Addendum to Change of Use Permit and Certificate of Occupancy for 219 Anderson Street,
Suite #2: Blue Lobster Urban Winery, LLC

Blue Lobster Diner Co.
219 ANDERSON ST
SUITE # 2
PORTLAND, MAINE 04101

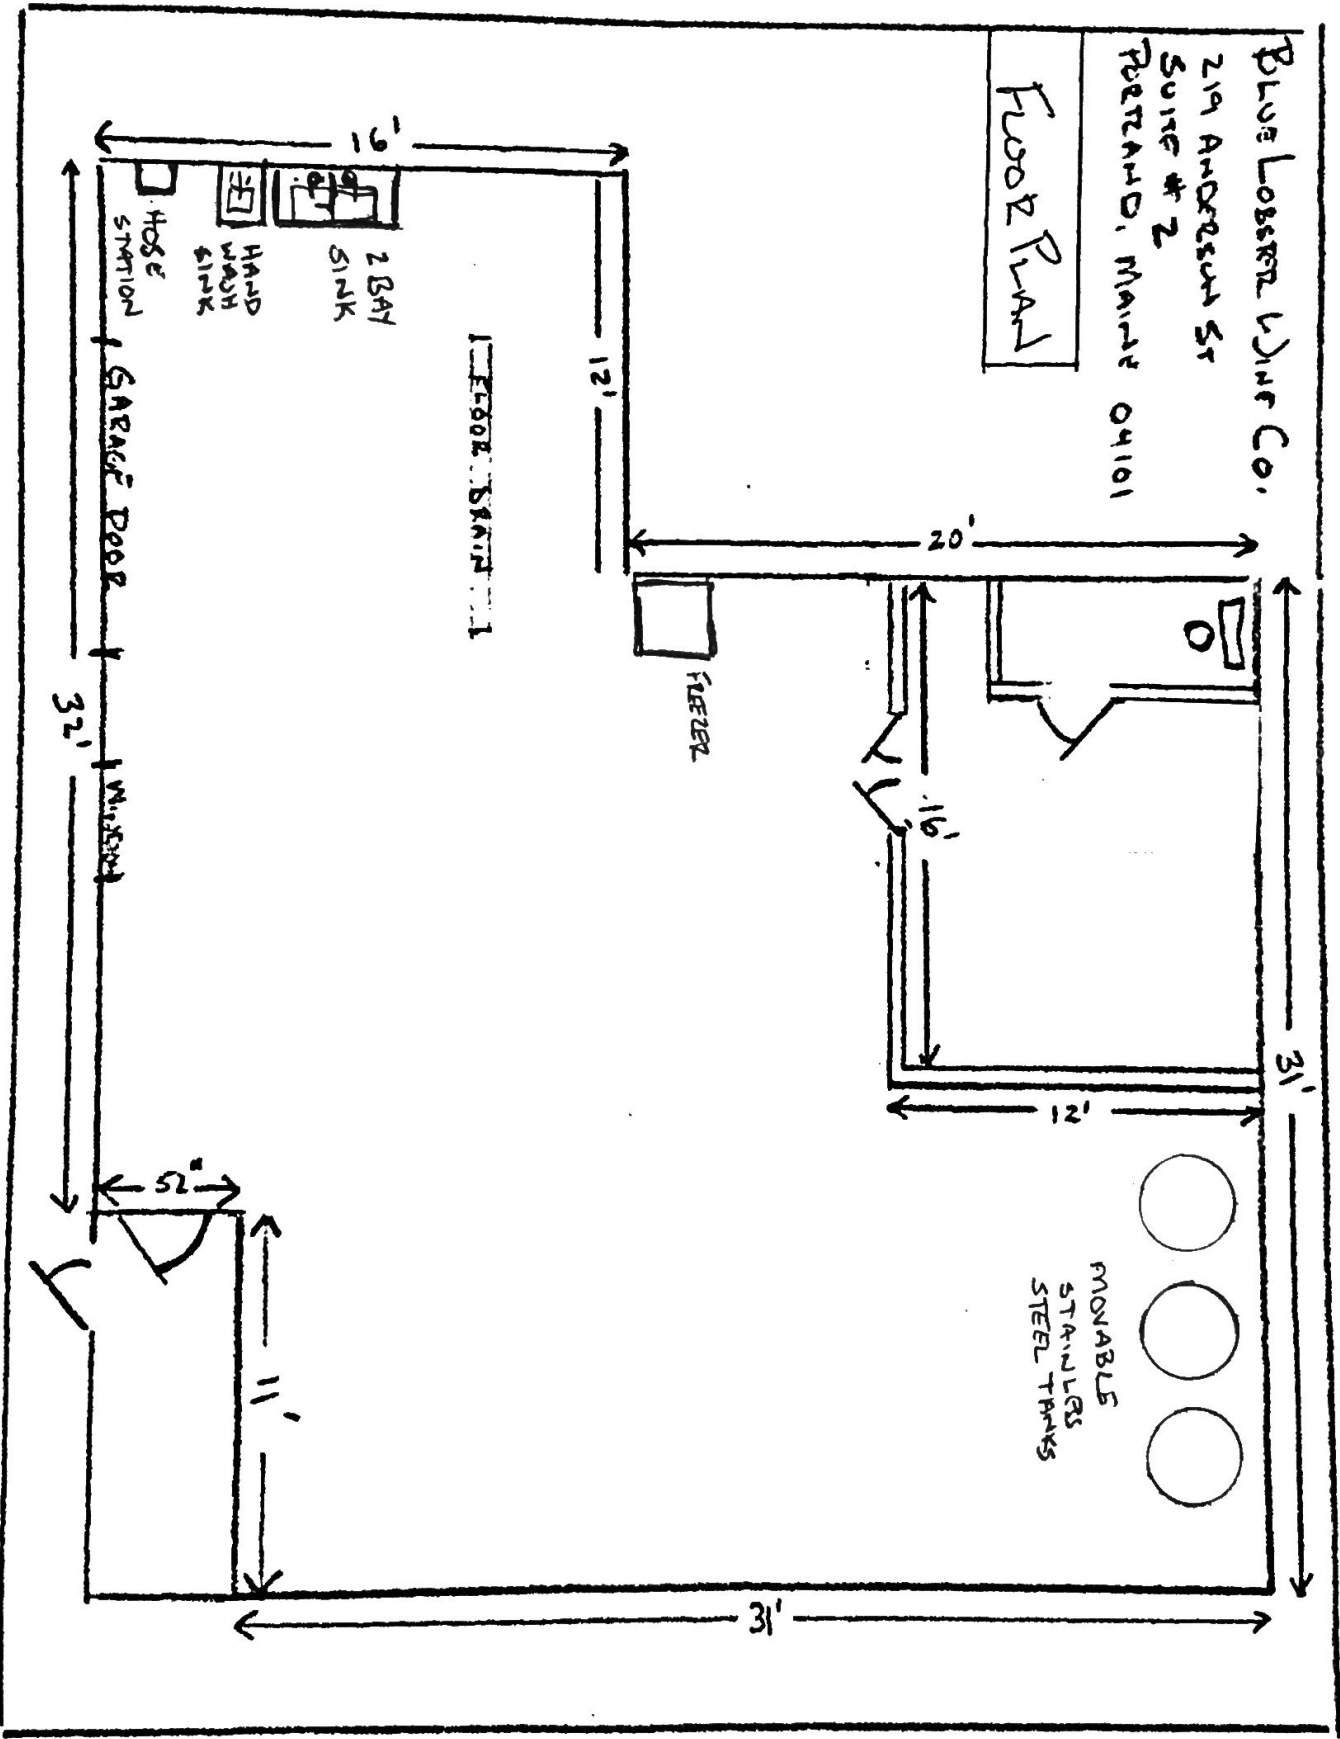
1. With a change of use, provide a detailed plan as current fire protection features, building construction type and proposed layout including occupant load.

- Current fire protection features are included in life safety plan. Note; facility not sprinkled.
- Building construction: brick, concrete, sheetrock, interior 2X4 walls
- Proposed layout: Space will remain open with small/movable equipment such as crusher/destemmer, press, and small tanks.
- Occupant load for industrial use in this 1740 sf facility: 17

Please note that Suite #2 is only being used as manufacturing with NO tasting room.
